DEVELOPMENT FACILITATION TEAM

Planning - Case Comments

Project Number: PR-2025-020108

Project Name: 8601 Eagle Rock

PROPOSED TYPICAL SECTION - EAGLE ROCK AVE NE

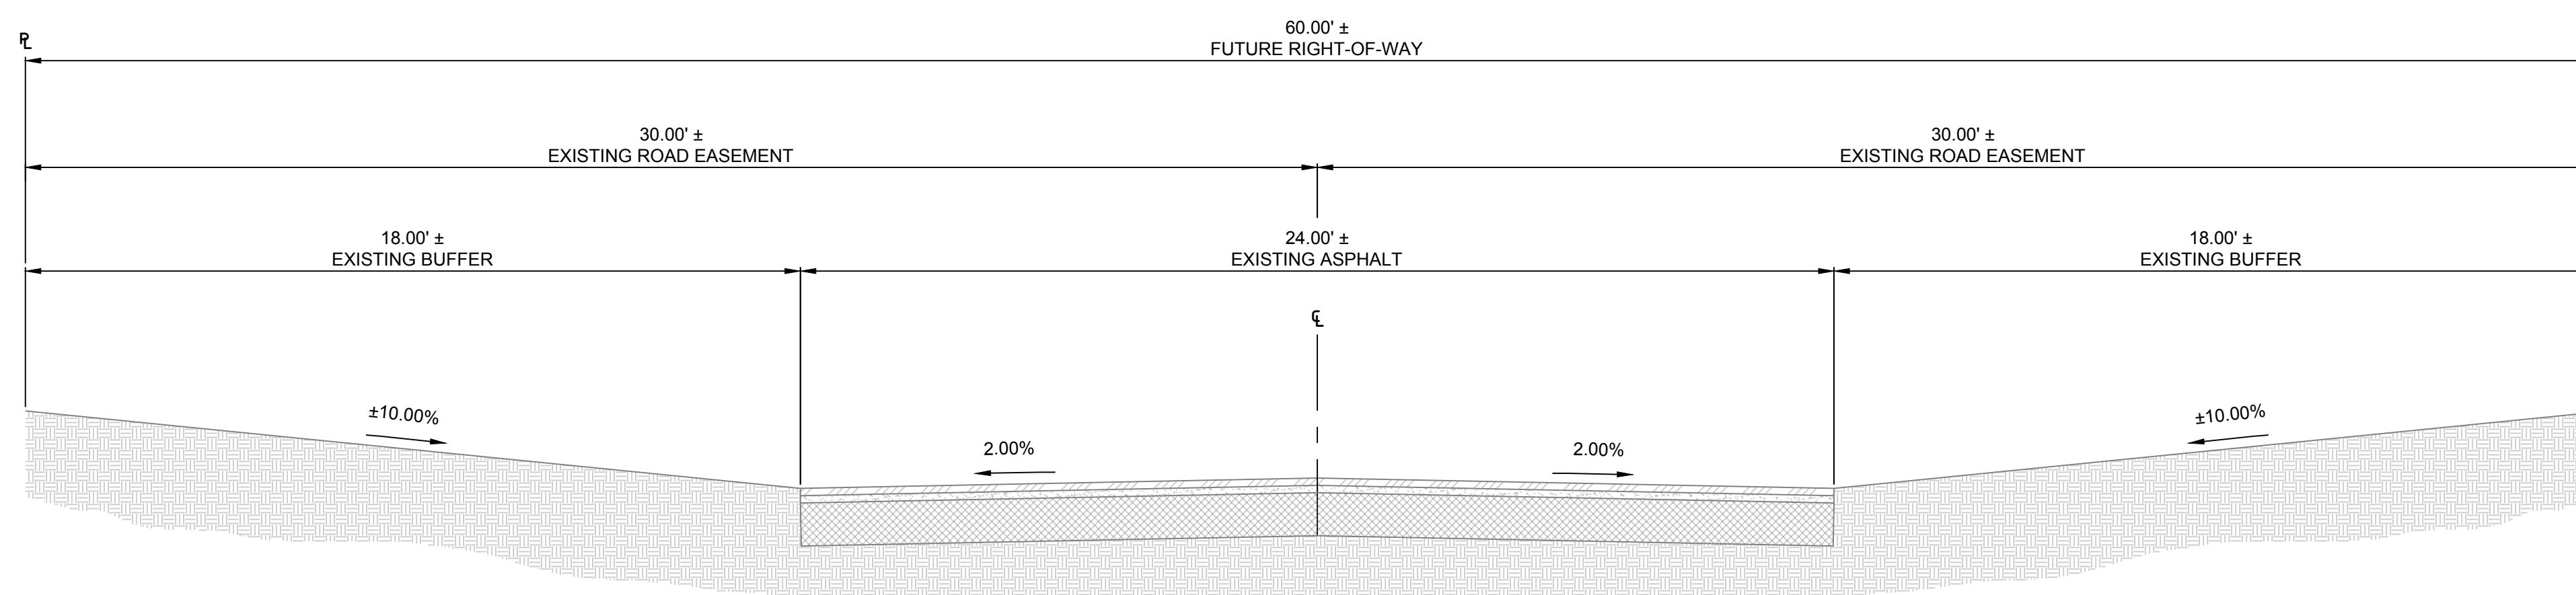
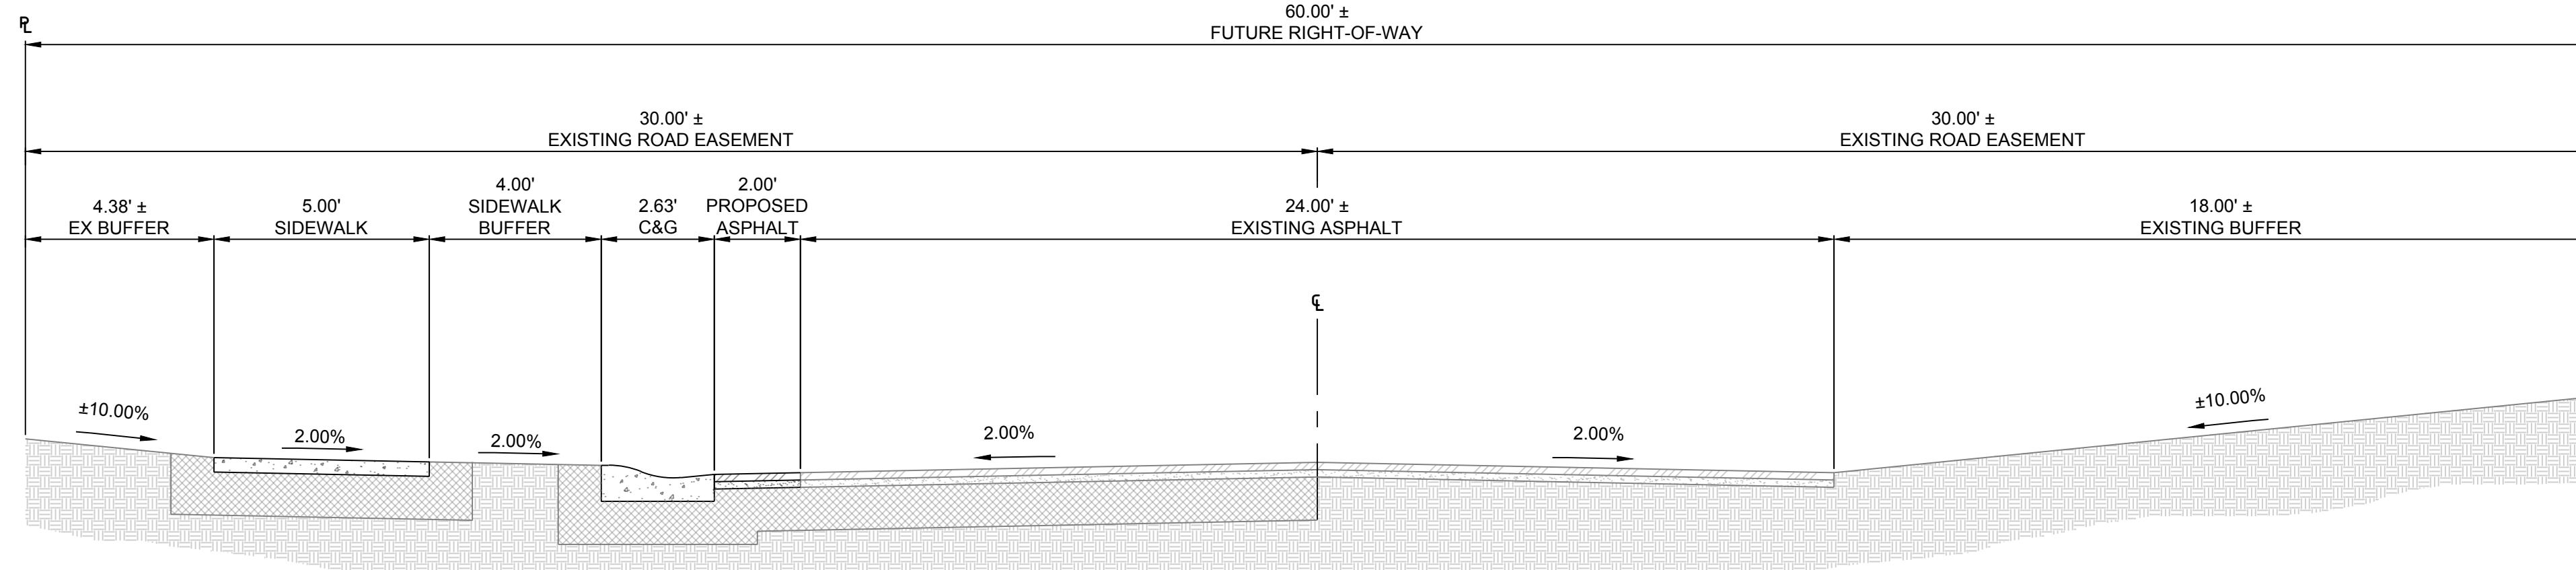
- Please be aware of standards within section 7 of the DPM Table 7.2.29 regarding Sidewalk width requirements and its landscape buffer.
Verification of DPM standards per Transportation
Any work within the ROW needs to be included on an infrastructure list.
Eagle Rock is a local road and requires curb, gutter, 5' sidewalk and a 4' to 6' landscape buffer.
All curb, gutter and public sidewalks must be on an infrastructure list and financially guaranteed.
